REQUEST for PARCEL SEGREGATION and BOUNDARY LINE ADJUSTMENTS

TO: Community Development Services
FROM: Christina Wollman, Planner II *cw*
DATE: January 2, 2007
SUBJECT: Hartman SEG-06-170, 20-17-28010-0004.

SUBJECT: Hartman SEG-06-170

DESCRIPTION: Boundary Line Adjustment/Administrative Segregation in the Rural 3 zone.

RECORD OF SURVEY

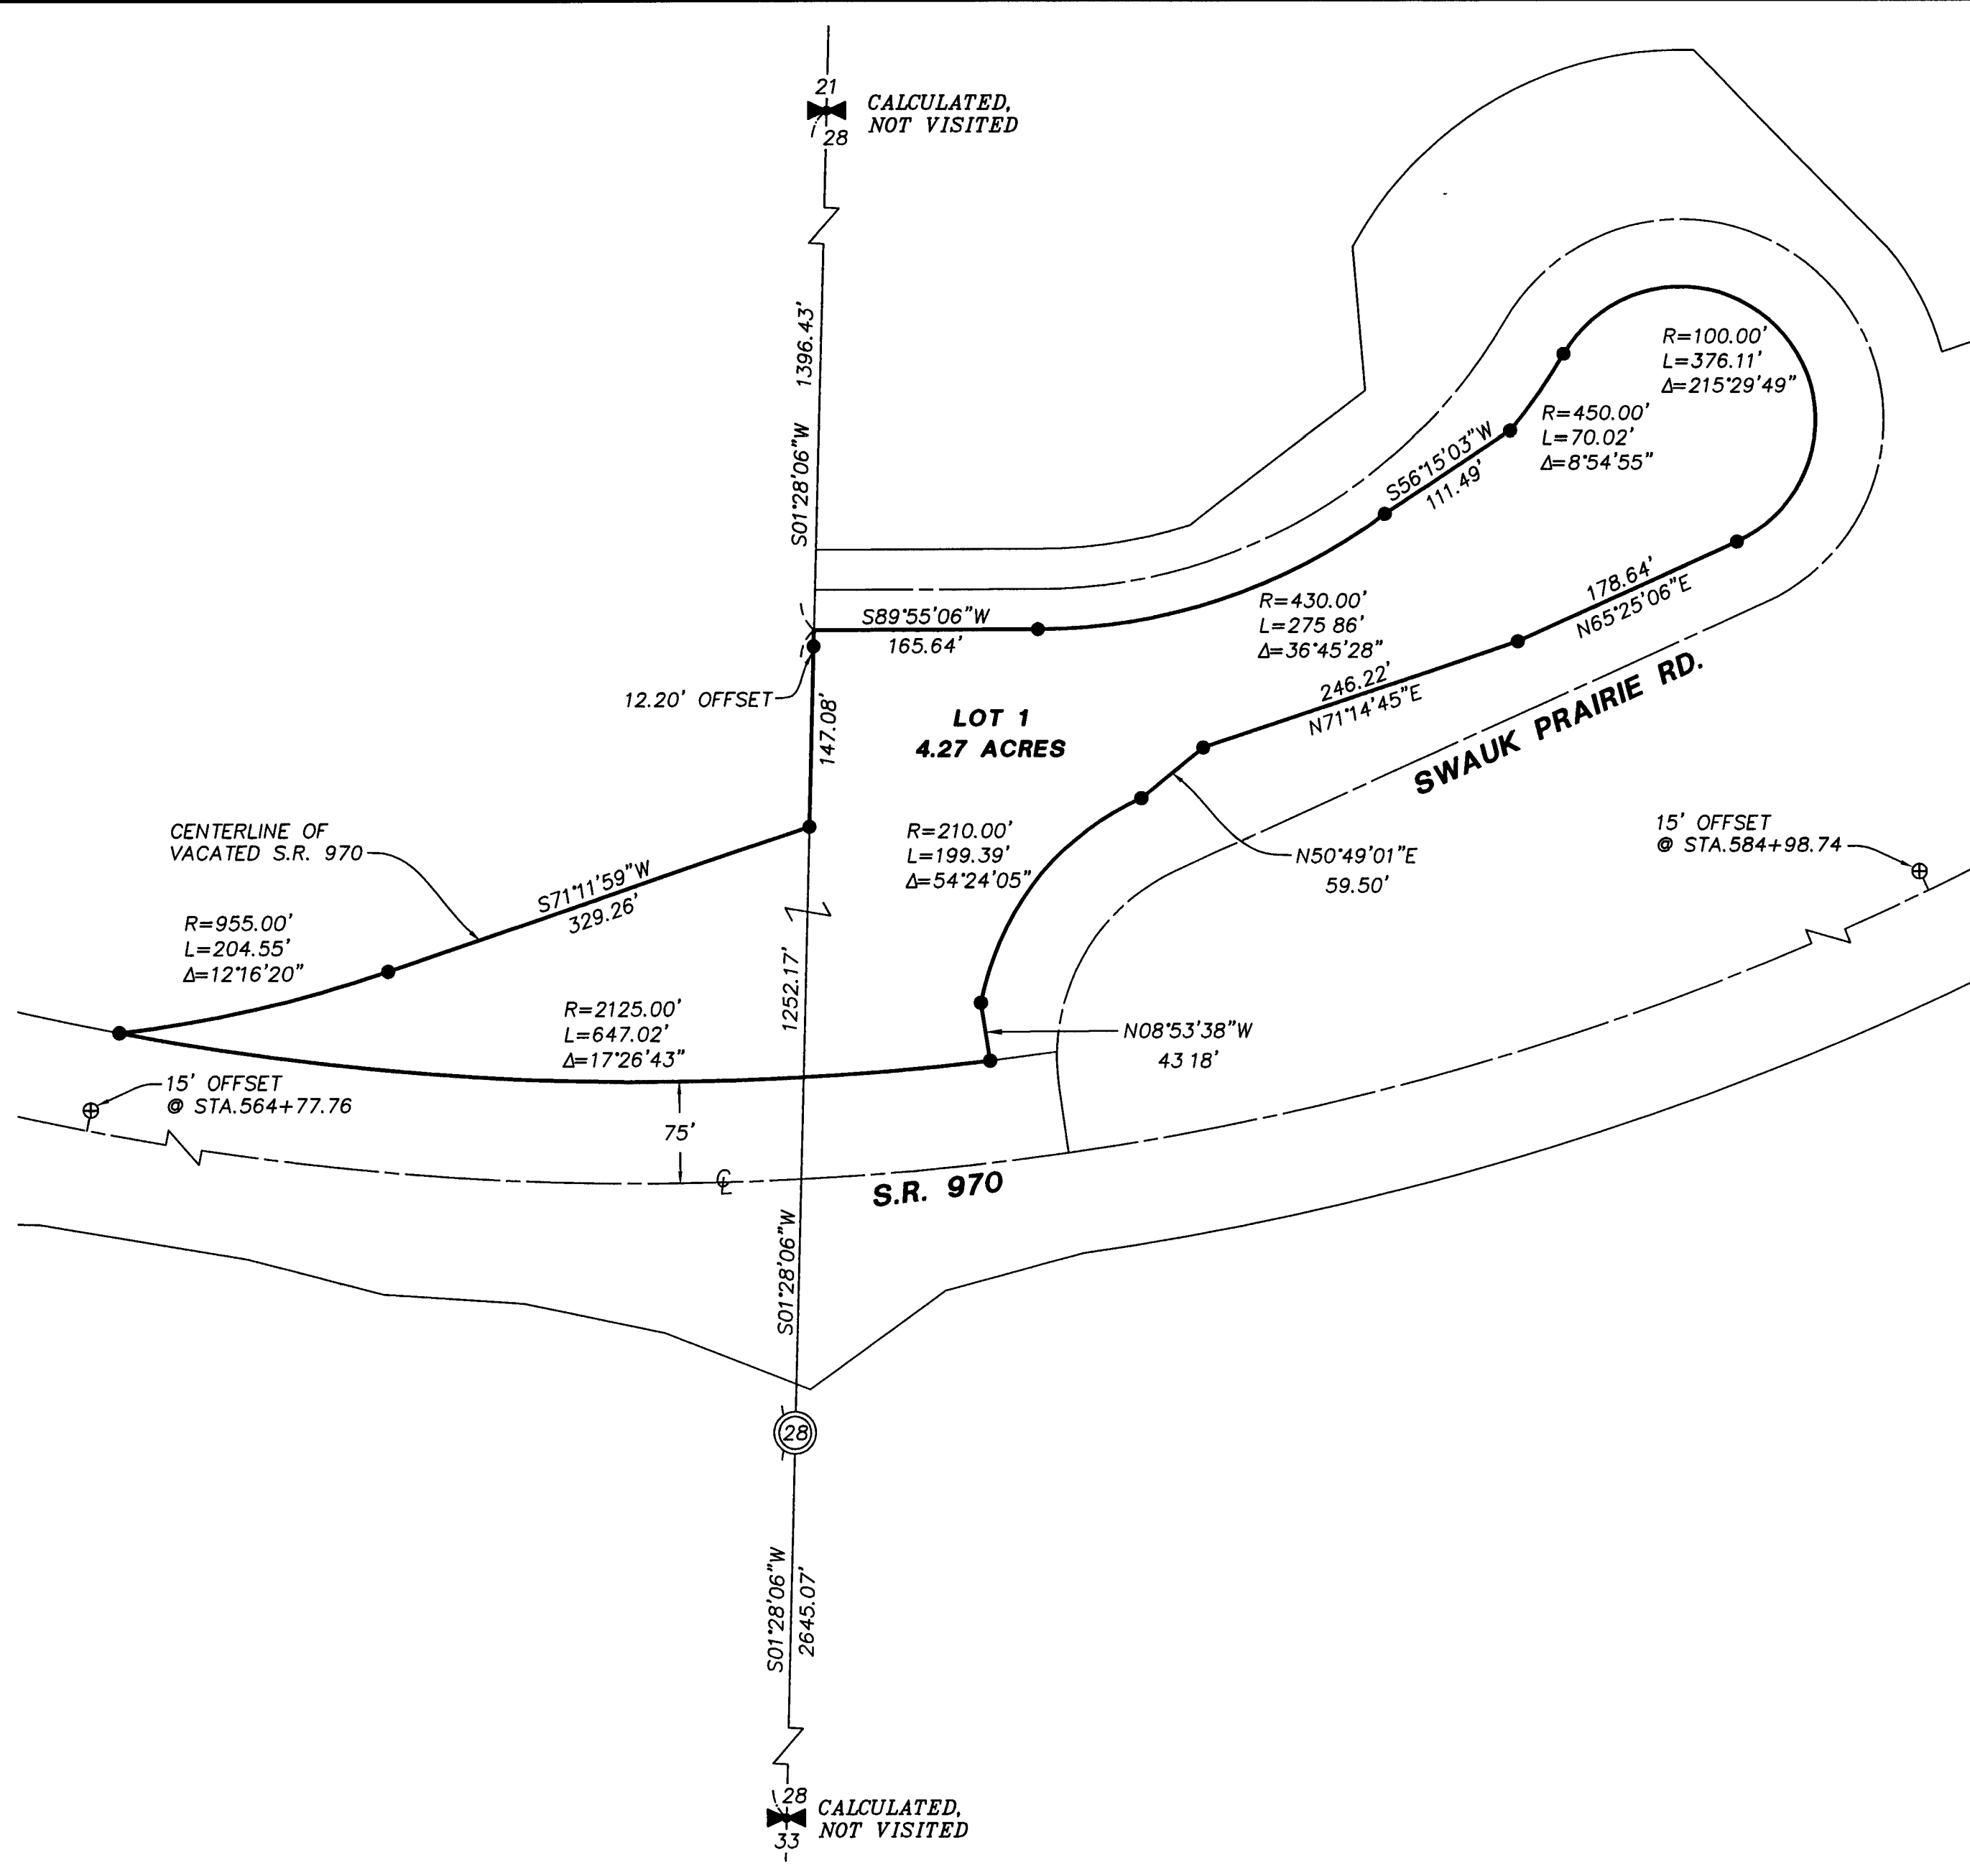
1. The proposed access with appropriate easement(s) shall be shown and shall conform to applicable Kittitas County Road Standards.
2. A revised legal description that describes the final configuration of the subject property shall be required.
